From: [Chad Gillespie](#)
To: [Chace Pedersen](#)
Subject: Sandelin Lane - Outpost Development
Date: Monday, November 13, 2023 7:18:45 PM

I wanted to express my concern for the proposed Outpost Development just off Sandelin Lane. We have owned property at 301 Sandelin Lane since 1965 and enjoy low traffic volume and low walking traffic. The proposed emergency access is concerning. Why does the development need an emergency access when they already have a main arterial access off the main road?

**CONCEPTUAL SITE PLAN
MULTIPLE PARCELS**

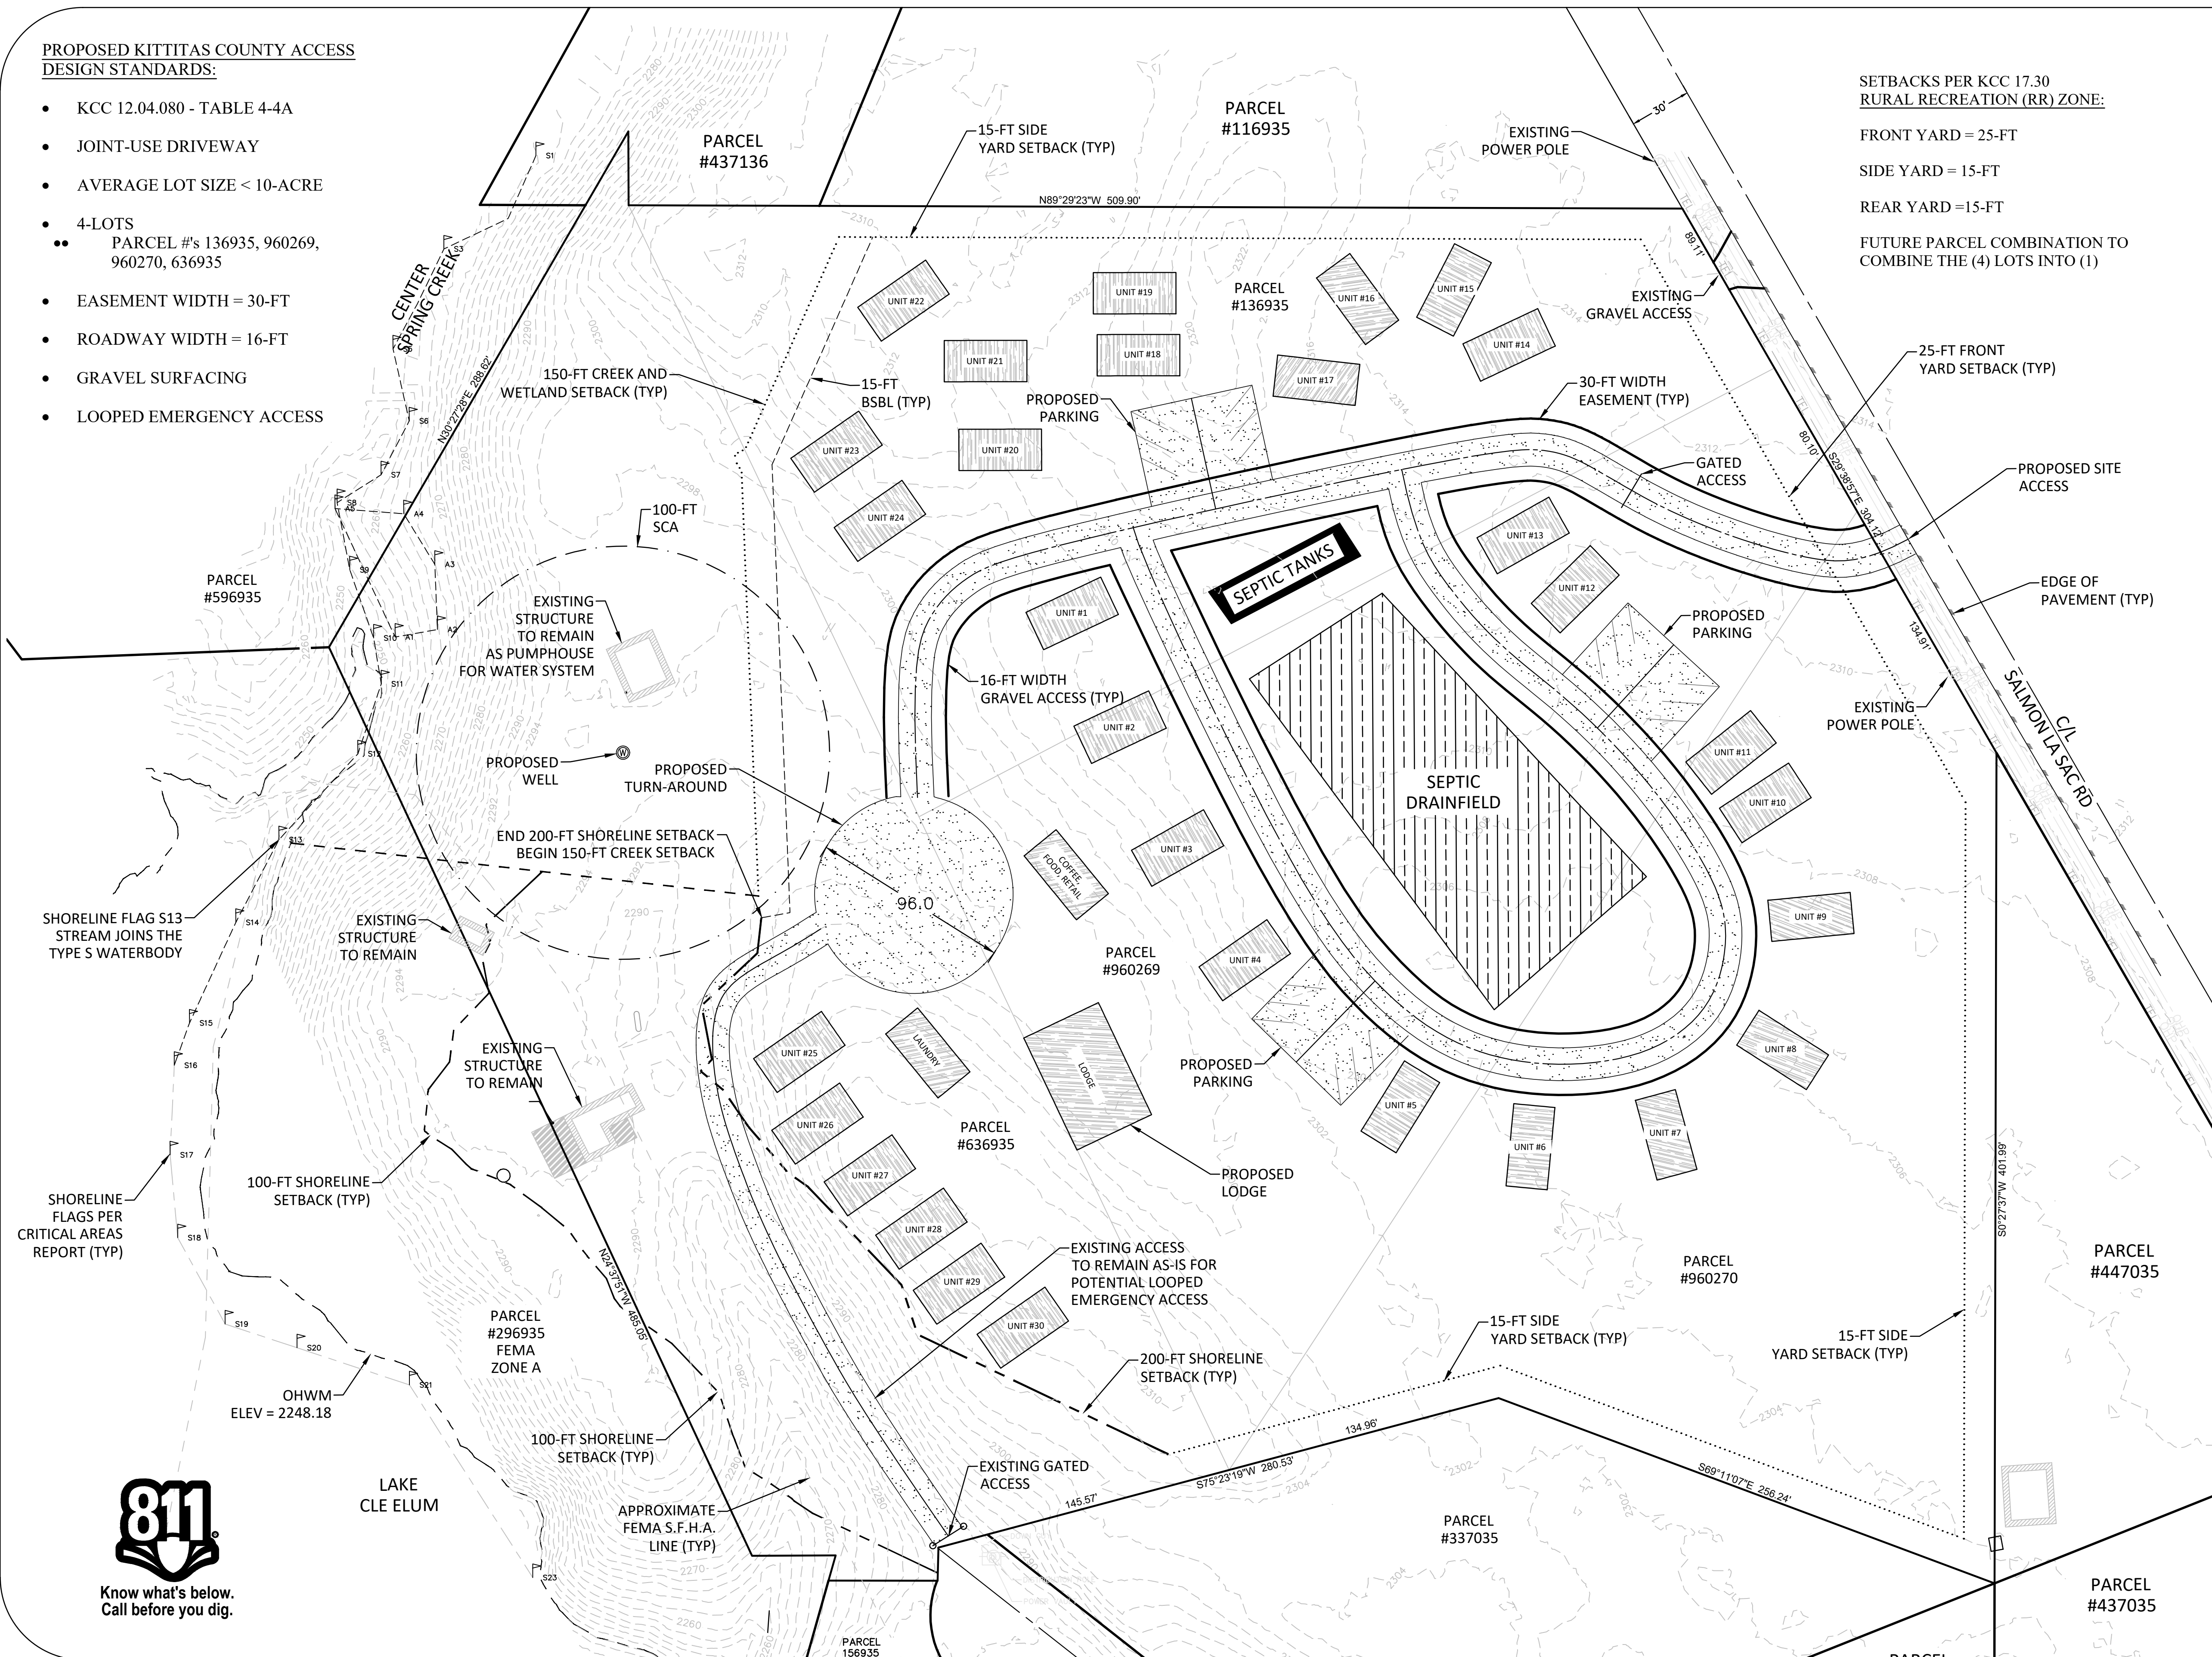
In my opinion they need to develop an alternate emergency access, on their property, if this is a code requirement and not utilize a road that is maintained by Sunshine Estate's HOA.

Please consider my concerns, and disapproval of utilizing our HOA maintained road, Sandelin Lane for this proposed land action.
